Please find attached the revised **Proposed Site Plan (Drawing No. PL-05 Rev B)**. This letter and the accompanying drawing submit the necessary amendments to address the specific concerns raised regarding pedestrian visibility splays, encroachment, and site safety.

19-12-2025

Drawn By: JM
Job Ref: 25071
Date: Nov 2025
Drawing No. PL - 05 Rev C

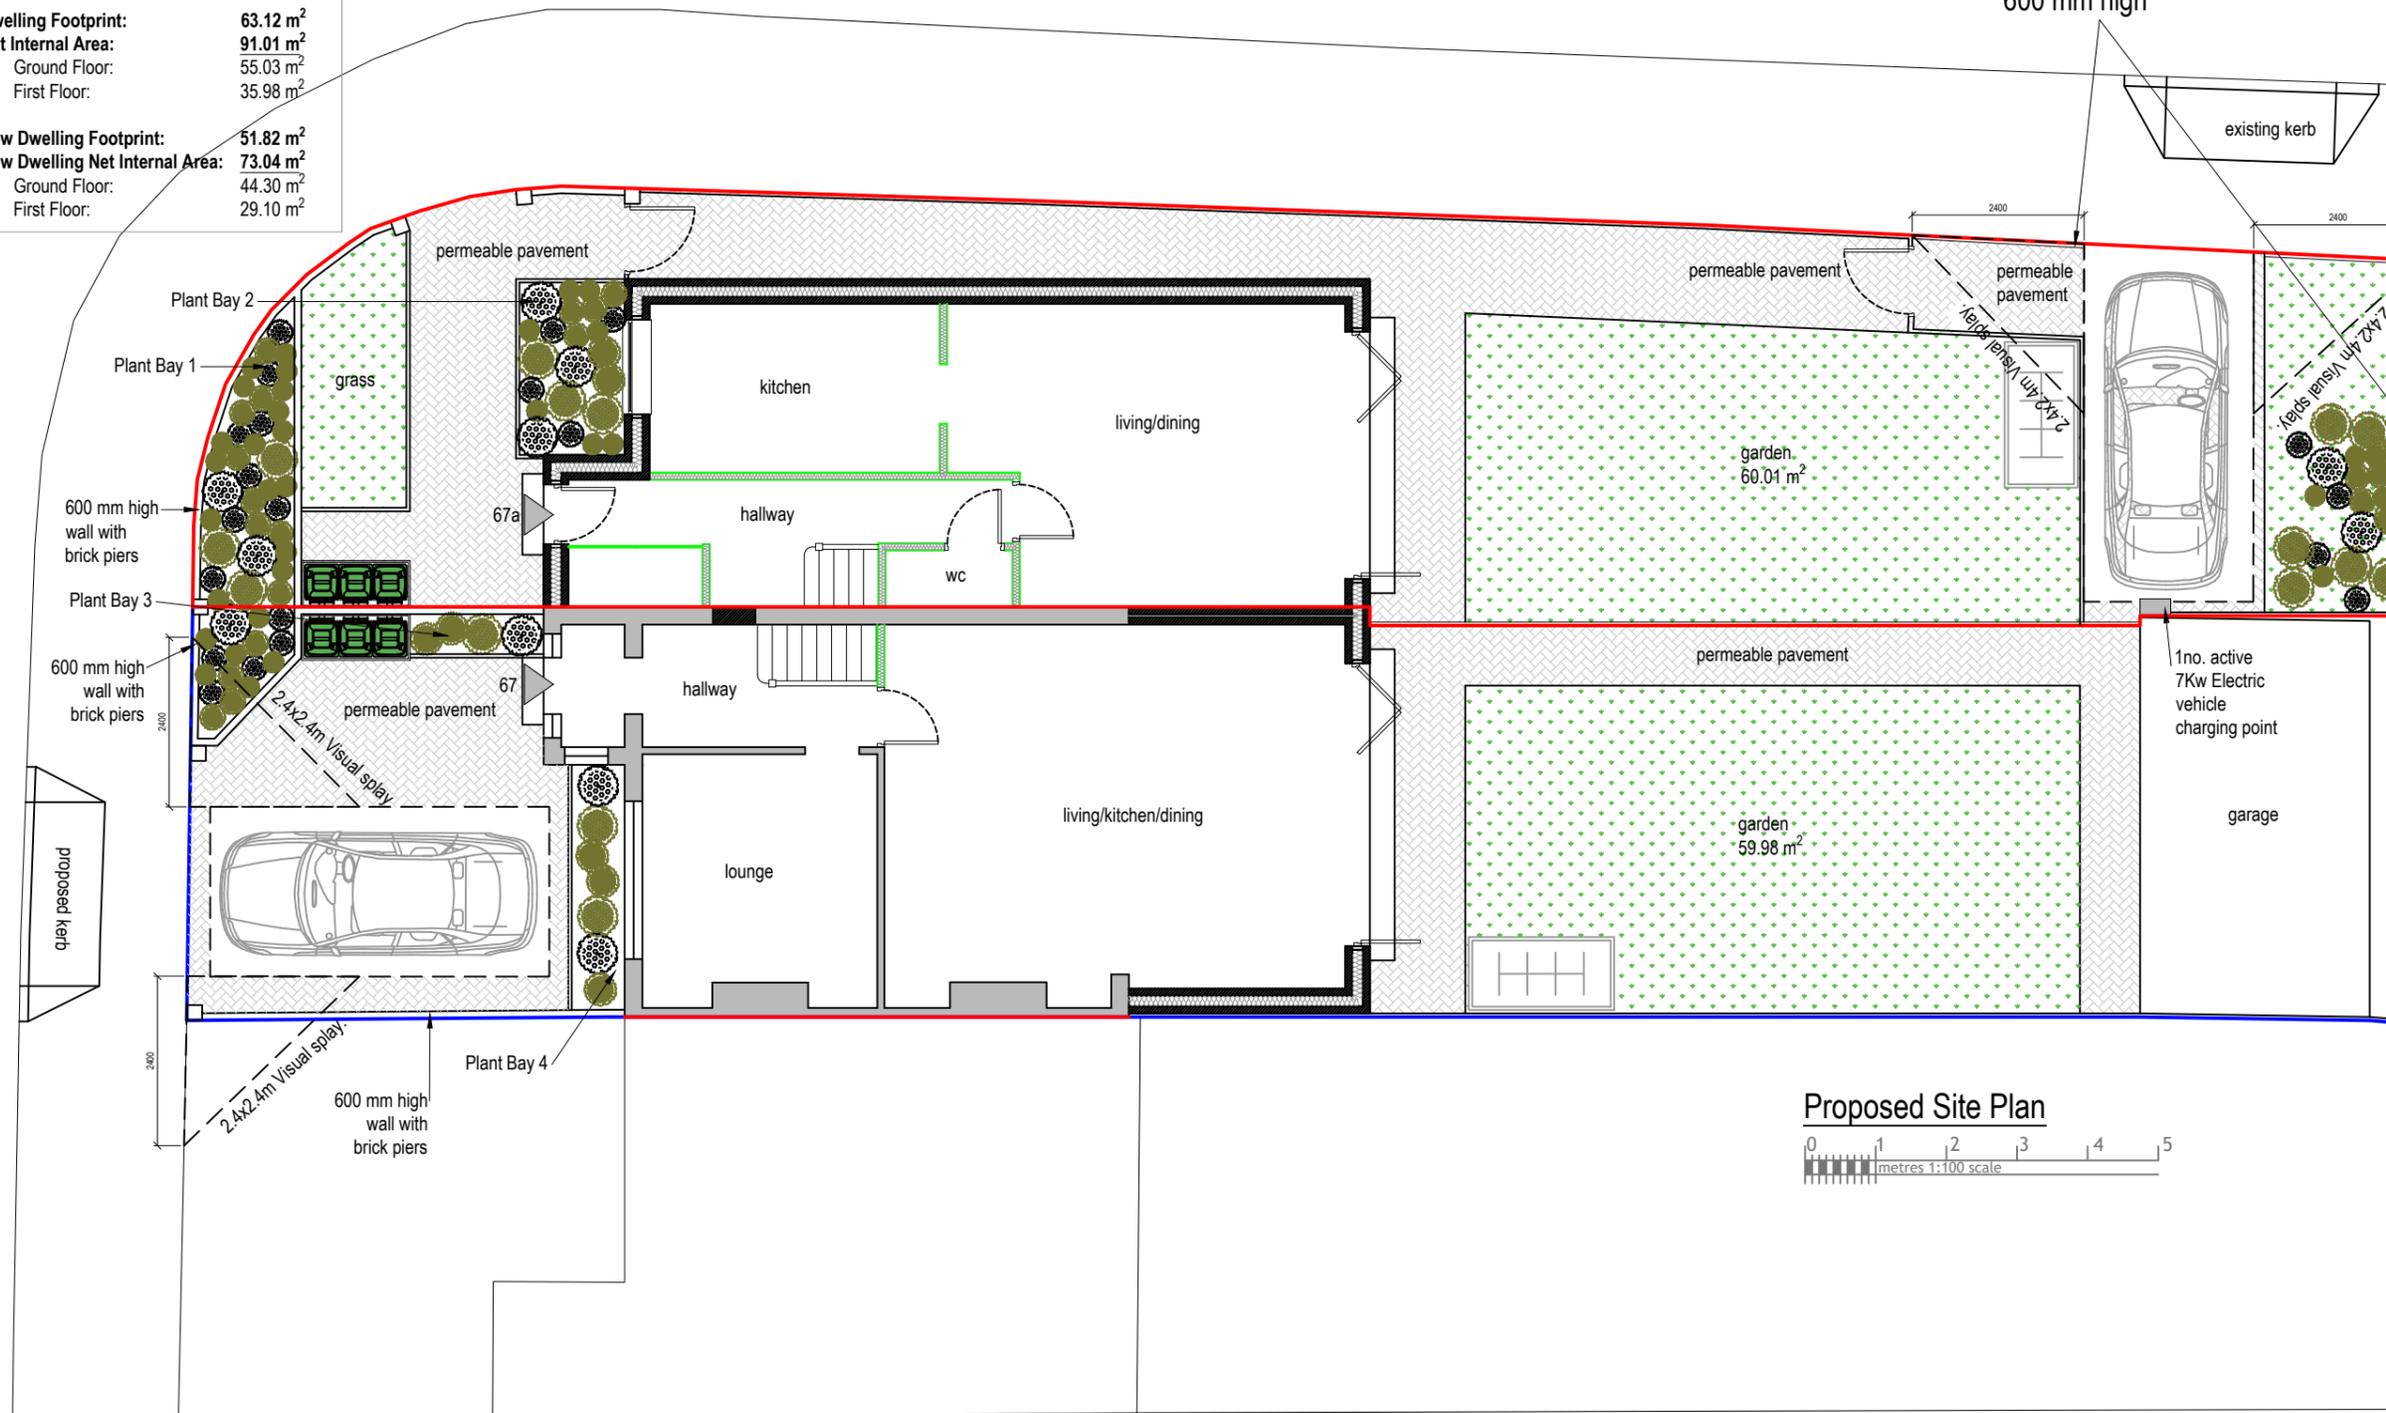
1. Pedestrian Visibility Splays (Compliance with Manual for Streets) The Highway Authority noted that previous iterations incorrectly illustrated the visibility splays. The revised plan **PL-05 Rev B** now strictly implements the required standards:

2. Physical Protection of Splays To address the concern regarding vehicles encroaching into these safety zones, the design now incorporates physical barriers:

- **Dimensions:** Pedestrian visibility splays measuring **2.4m x 2.4m** have been accurately plotted on either side of the vehicular access points.
- **Height Restriction:** We confirm that within these visibility triangles, no obstruction will exceed **0.6m** in height. The boundary treatment is explicitly labelled as a "**600 mm high wall**", ensuring clear intervisibility between exiting drivers and pedestrians on the footway.

- **Dwarf Walls & Planters:** We have introduced "**Plant Bay 1**" and "**Plant Bay 4**" bordered by low brick piers/walls along the splay edges.
- **Prevention of Parking:** These permanent structures physically prevent vehicles from parking in the visibility triangle, thereby preserving the required sightlines at all times in accordance with **Hillingdon Local Plan Part 2 Policy DMT 1**.
